Your Ref: OWPC21316
Our Ref: R/12/19/HH 21-01-2019
Please ask for:
Stuart Corbey

Extension to conservatory, first floor side extension, external staircase, balcony area on first floor, alteration of windows on rear first floor & balcony doors & new window on ground floor side elevation.

Anchors Cast 2 Fosters Close Rustington

Drawing Title:
Proposal Plans 11

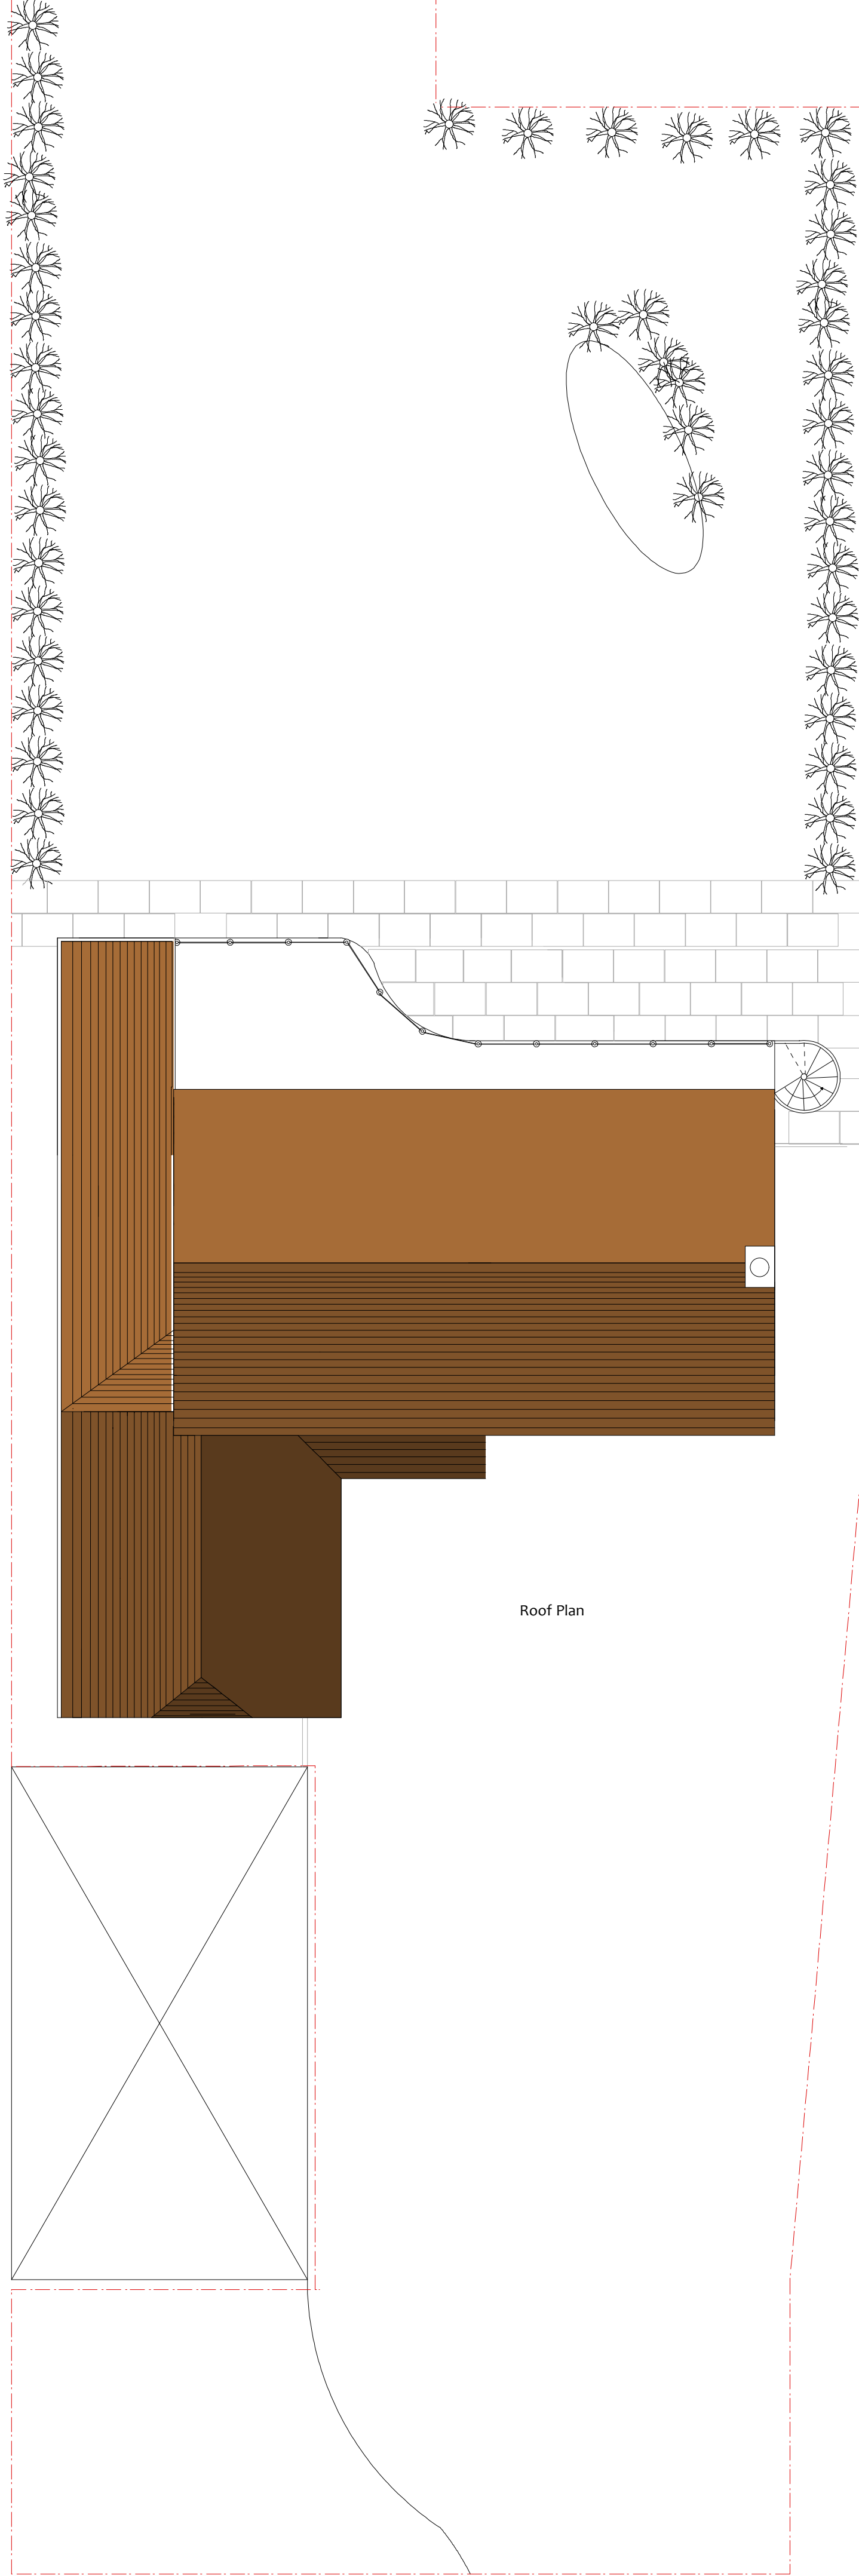
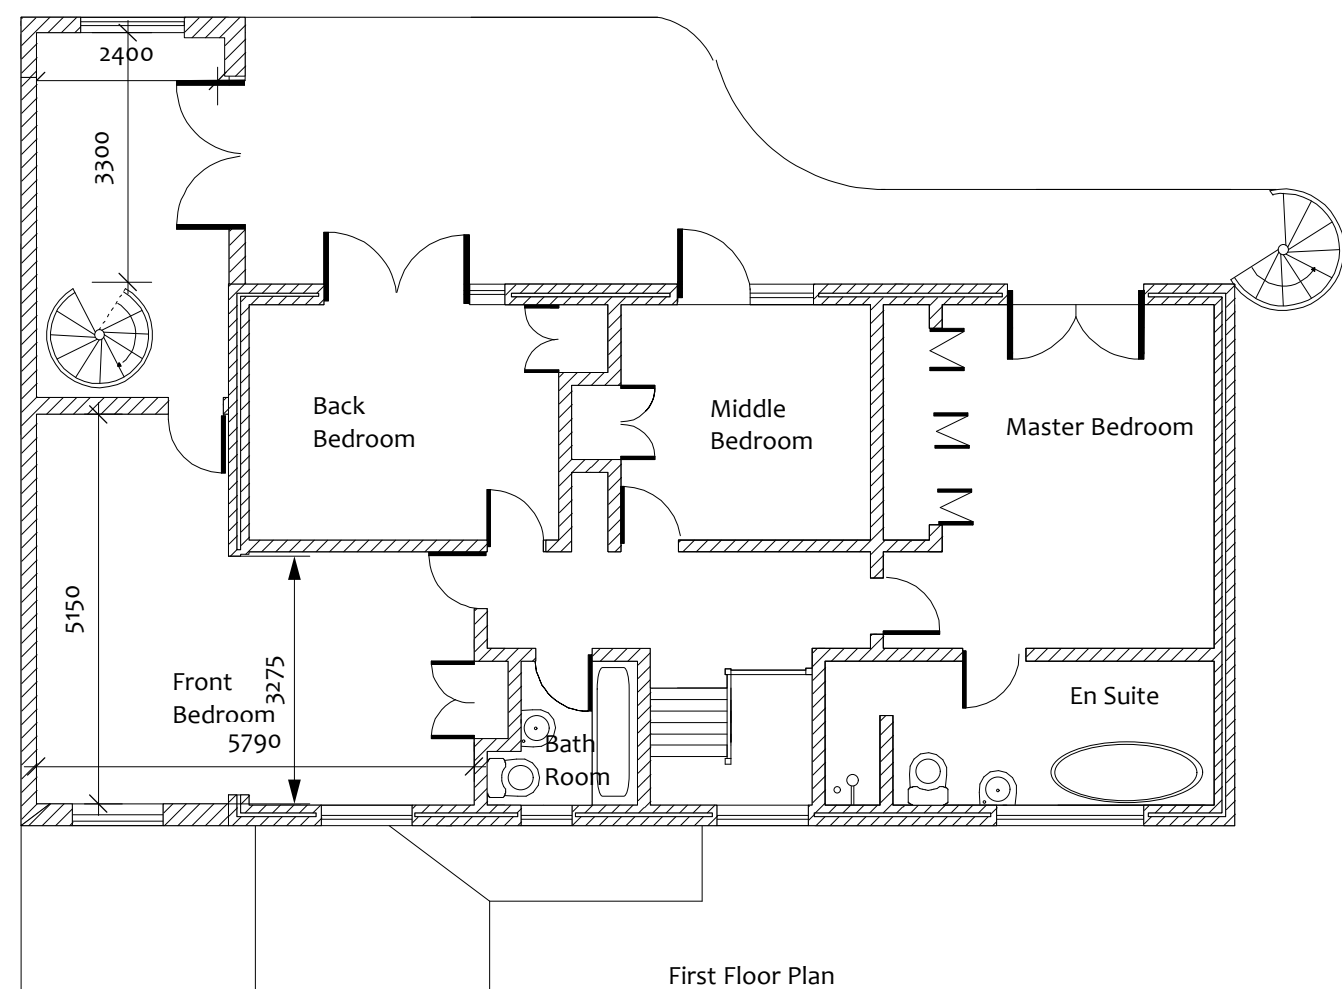
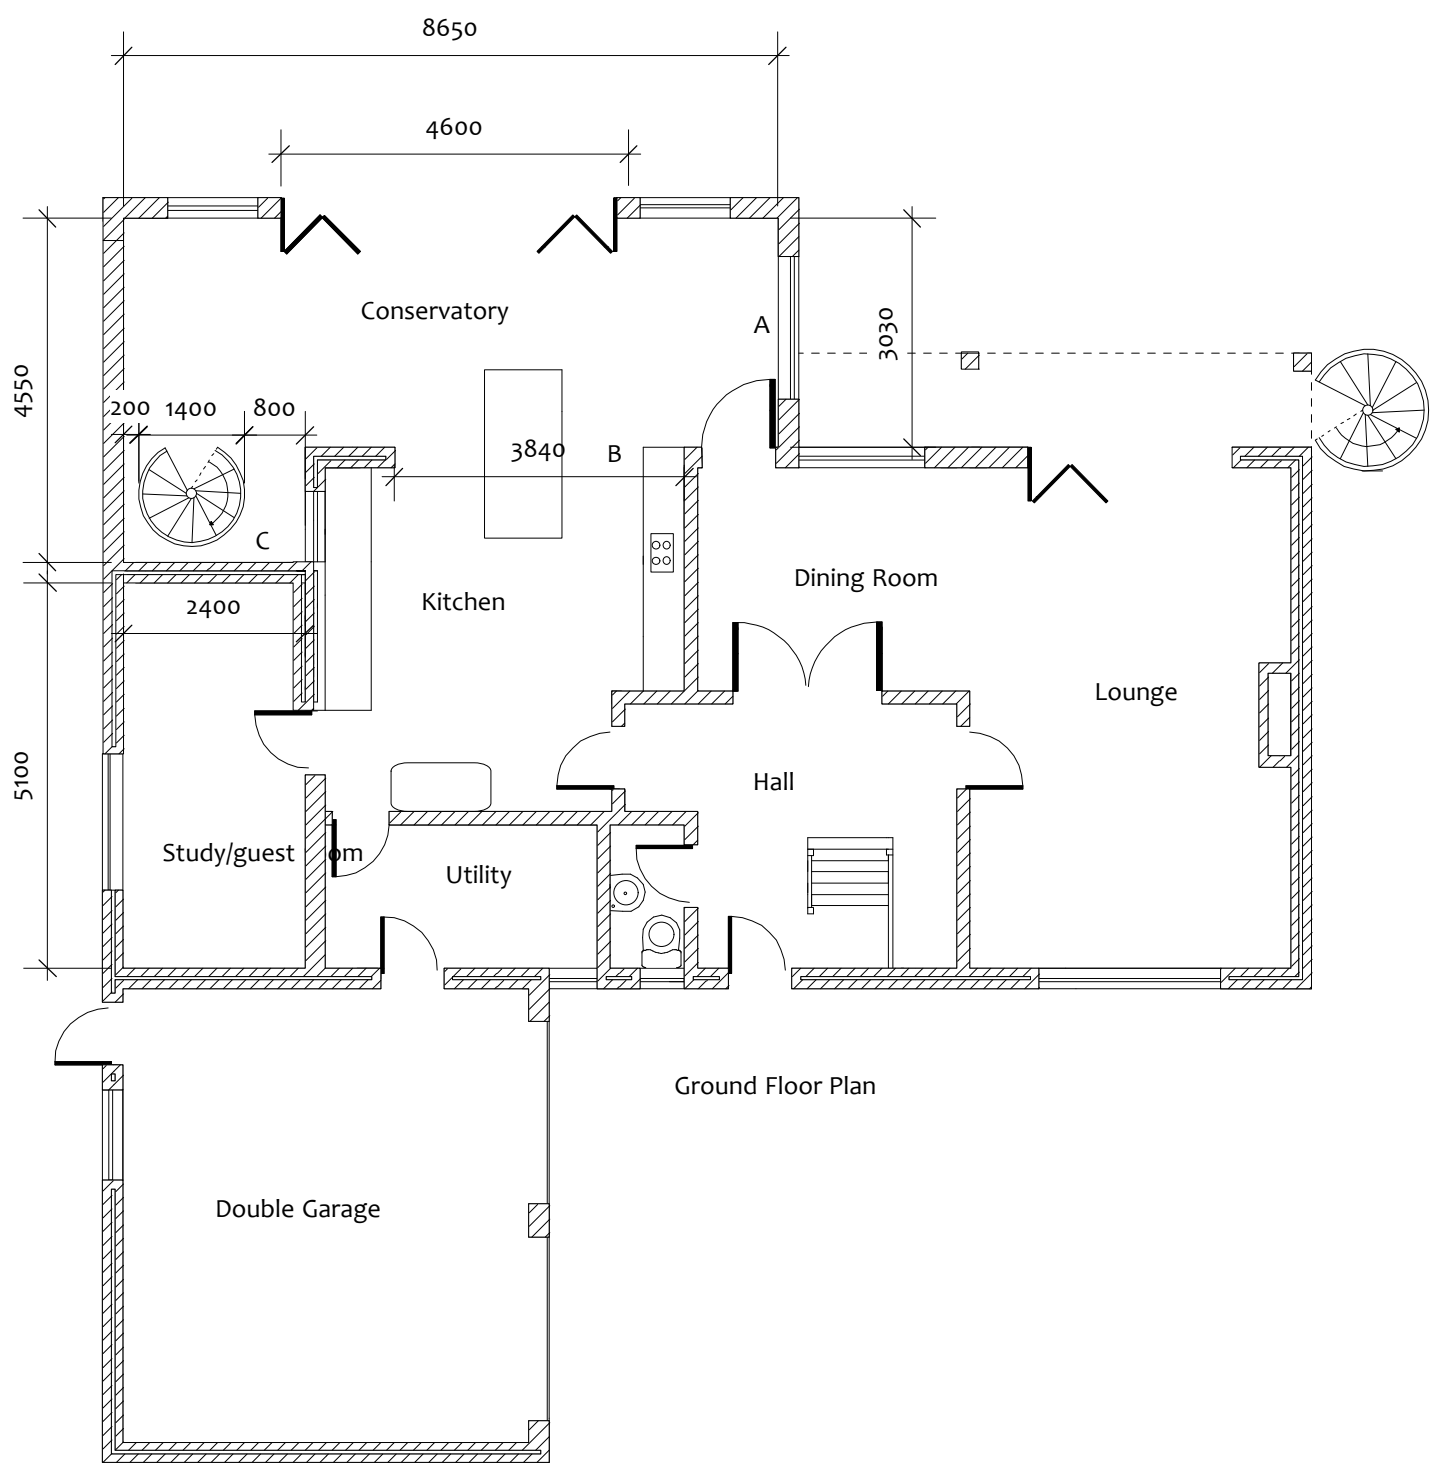
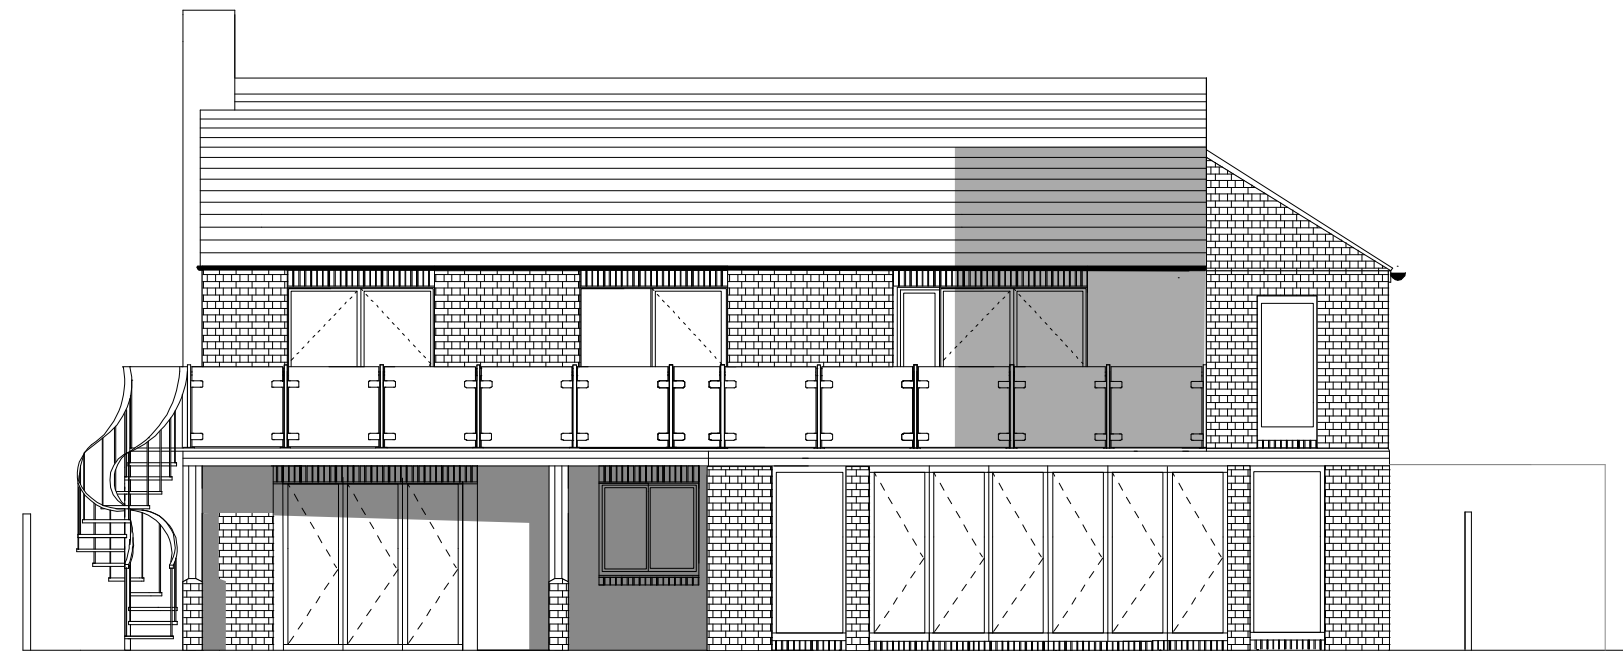
It would seem to me from the plans that the proposed balcony and external staircase at Number 2 Fosters Close will allow an excessive degree of 'overlooking' of the patio, rear and side garden and glass kitchen door of my mother's house when compared to the existing view from the rear bedroom windows of Number 2. It is of note that Number 2, which would have been constructed around the same time as Number 3, was designed with no windows on its western flank, presumably to afford Number 3 privacy.

In particular the location of the proposed external spiral staircase at the western end of the balcony is a cause for concern as it is will be so close to the boundary fence as to be almost touching it, due to the existing narrow passageway between the flank wall and boundary fence at Number 2. The plans show the proposed balcony can be accessed by two other routes, ie the bedrooms' French doors and the proposed internal spiral staircase. I would I query the necessity for the external spiral staircase, given its close proximity to and impact it will have on my mother's property.

In order to maintain the existing privacy of the rear garden of Number 3 it would seem reasonable to request that the plans be altered to (a) remove or relocate the external spiral staircase and (b) include a built screen at the western end of the proposed balcony at Number 2, especially as there is no room here either side of the fence to allow a hedge to be grown as a natural screen.
